RE: **Montgomery Carwash**
3525 Montgomery NE
Grading Plan Stamp Date: 10/31/18
Hydrology File: F16D053

Based on the submittal received on 11/1/18, the Grading and Drainage Plan cannot be approved until the following are corrected:

|   | GRADING AND<br>DRAINAGE PLAN        |  |

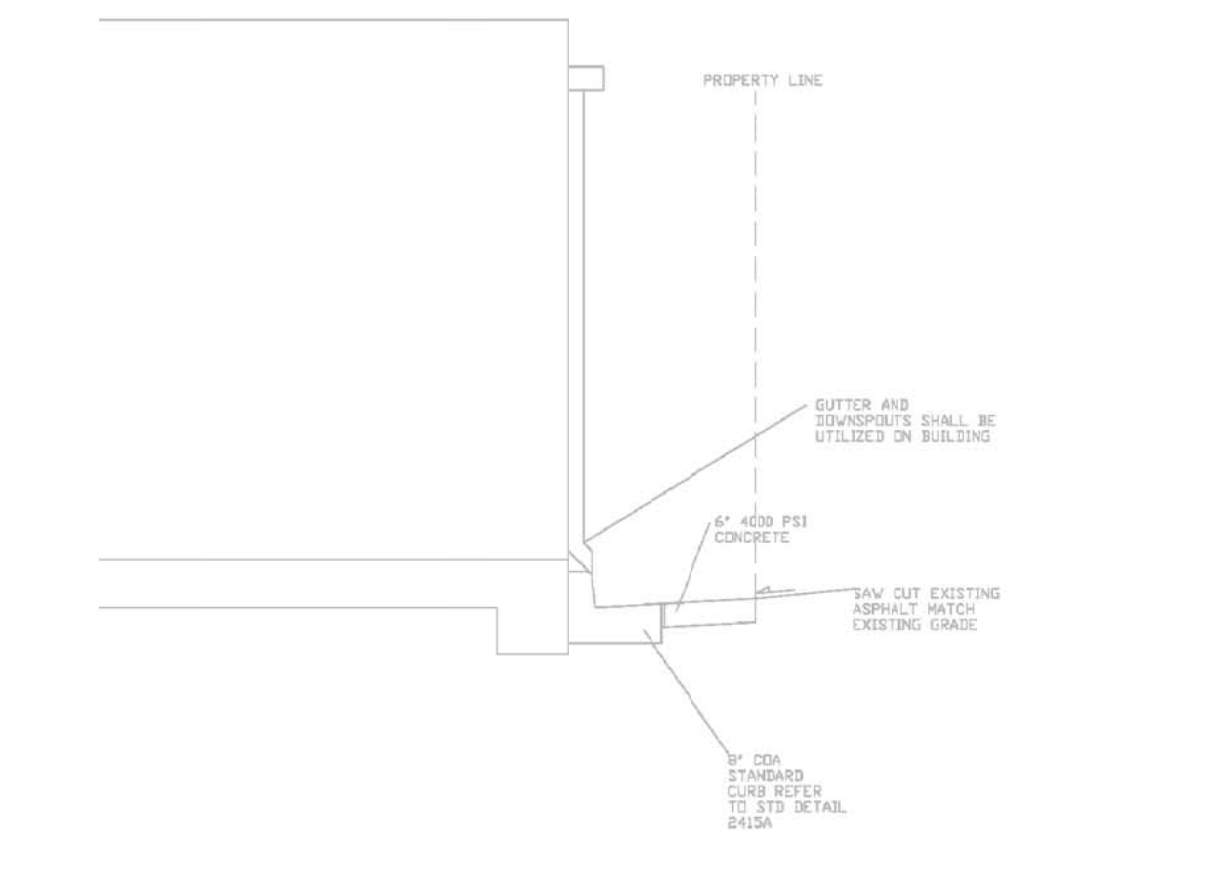
1. Basin C delineation needs to be shown on the plan. It is unclear how any of Basin C makes it to a stormwater quality pond.

2. Provide management onsite for the entire Stormwater Quality Volume in accordance with the new drainage ordinance, § 14-5-2-6 (H) enacted 10/2/18 (Council Bill C/S O-18-2). This site qualifies as redevelopment and is only required to manage runoff from the 80th percentile storm ($\text{Vol.} = 0.26'' \times \text{Imp. Area}$).

3. Each stormwater quality pond need to be sized for the area draining to it. These areas need to be clearly delineated and shown on the plan, or as a separate exhibit.

TYPICAL SECTION AT EAST PROPERTY LINE

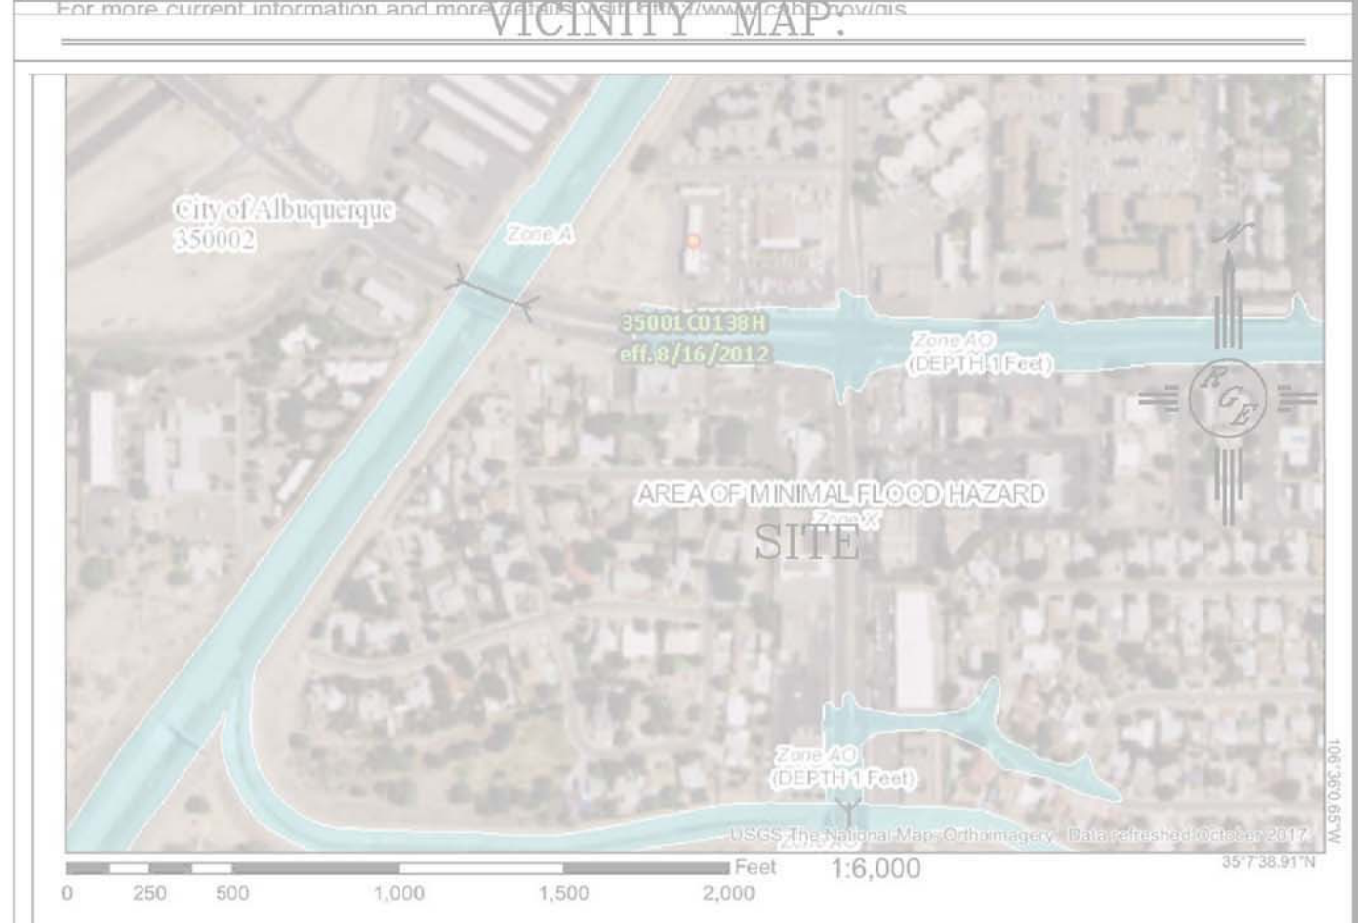
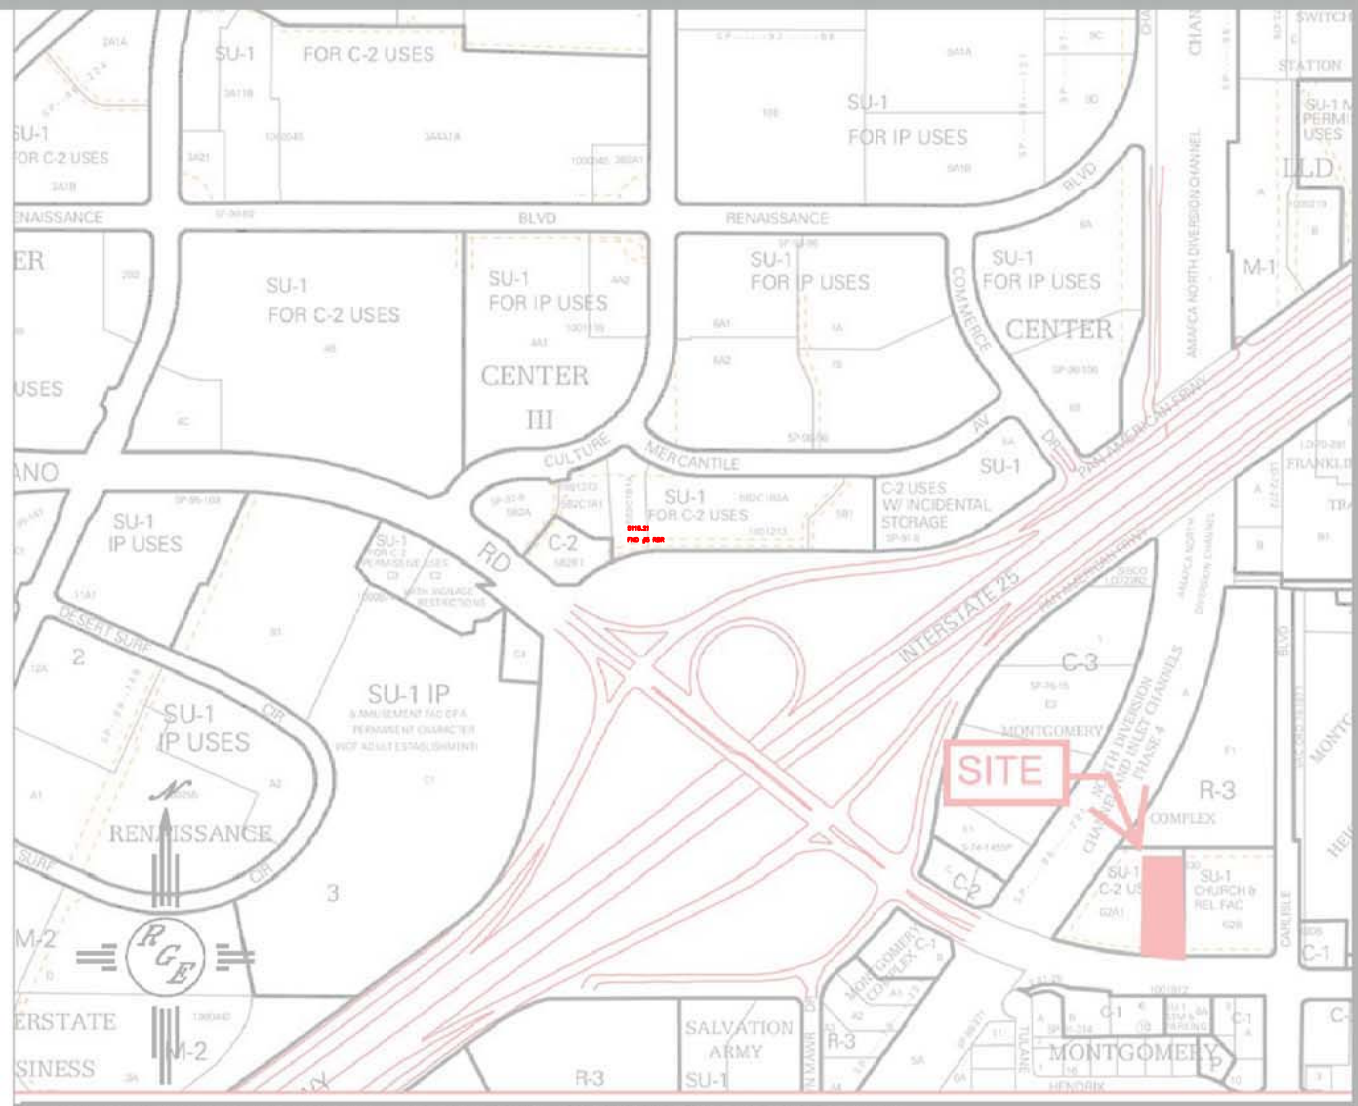
4. Provide a section through the building and east property line. How will the channel manage the roof runoff and the offsite flows? Please show the channel in plan view.
